APPLICATION REF: EN010103 – THE NET ZERO TEESSIDE PROJECT

REQUEST FOR FURTHER PROPOSED CHANGE TO THE NET ZERO TEESSIDE DEVELOPMENT CONSENT ORDER ('THE NET ZERO TEESSIDE ORDER') APPLICATION – REMOVAL OF TEES DOCK ROAD ACCESS

LAND AT AND IN THE VICINITY OF THE FORMER REDCAR STEEL WORKS SITE (TEESWORKS SITE), REDCAR AND IN STOCKTON-ON-TEES

- KEY
- Order Limits (Site Boundary)
 - Detailed Sheet Number - Work No. 10 - Access and Highway Improvements
 - Areas within which each Work Number may be constructed:
 - Work No. 10 - Access and Highway Improvements

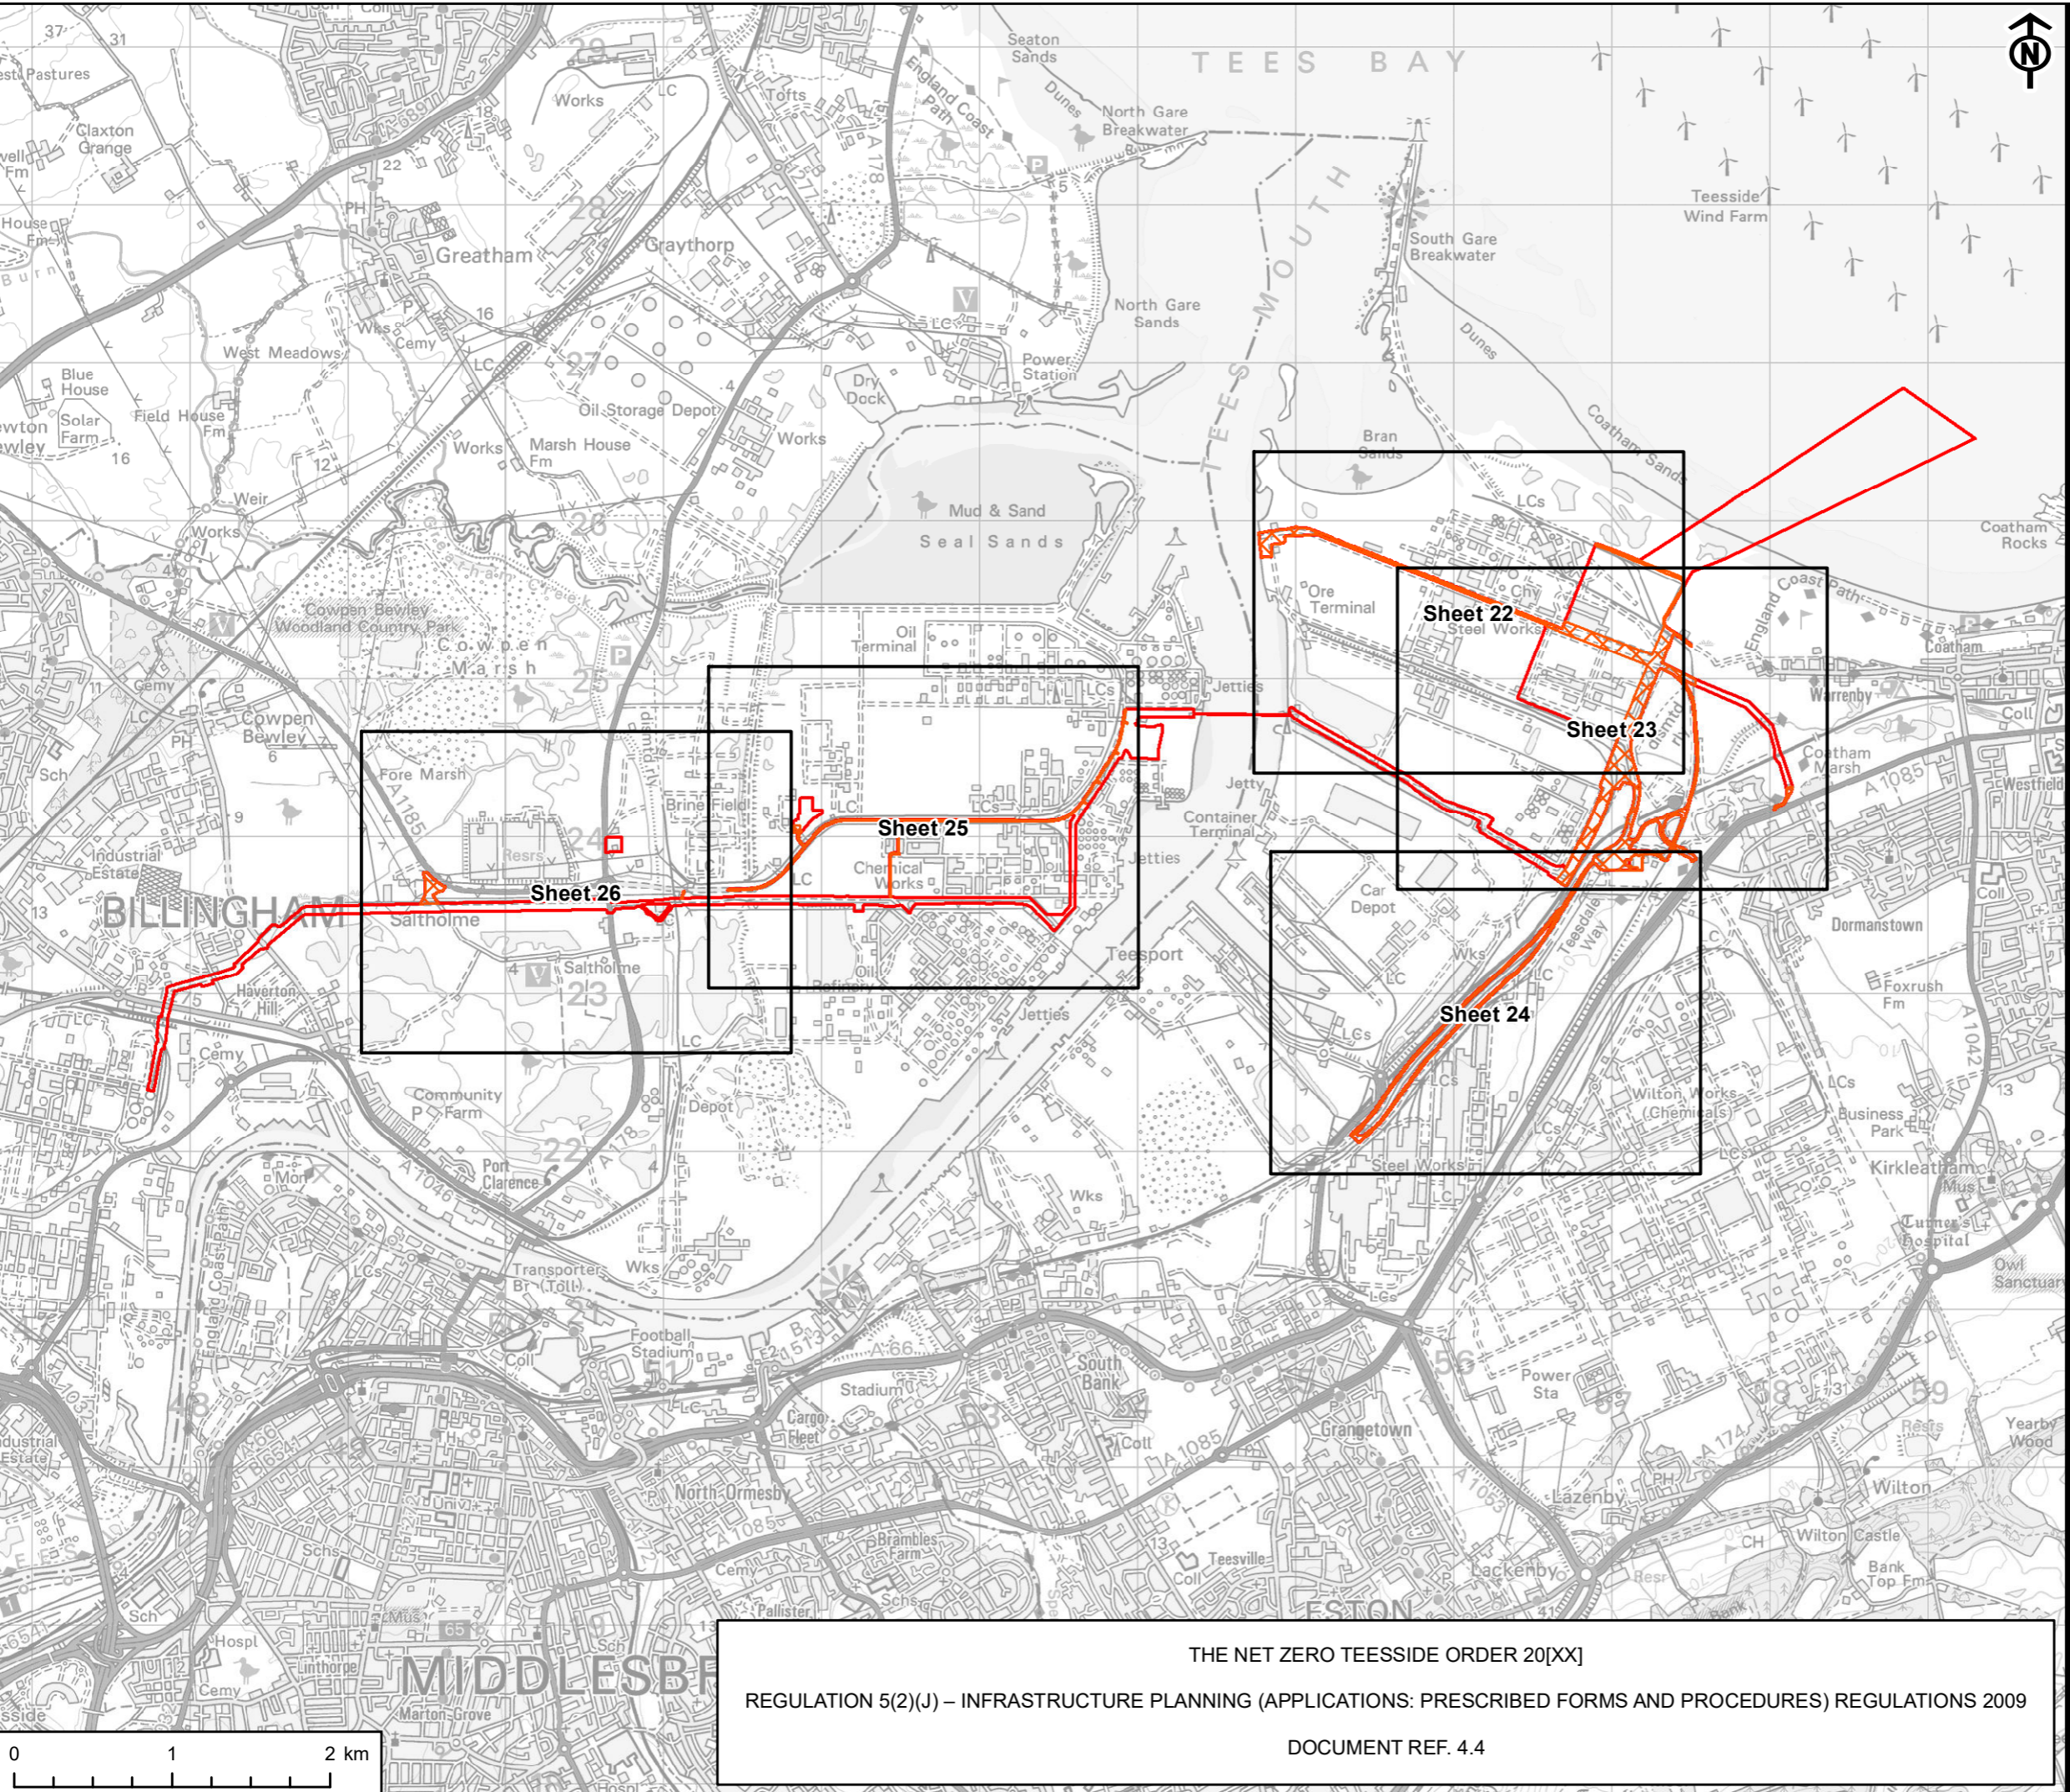
A legally binding agreement has now been reached with STDC in respect of the main site which secures arrangements for access and therefore the Applicants are now in a position to remove the Tees Dock Road Access from the Application (subject to the agreement of the Secretary of State), meaning that the Applicants are in a position to further reduce the extent of the Order Limits and Order Land.

Change No.	Description
19	Proposed Change: Removal of temporary possession Order Land associated with the development and use of an access from Tees Dock Road Access, resulting in a reduction in the Order Land/Limits (part of Work No. 10).
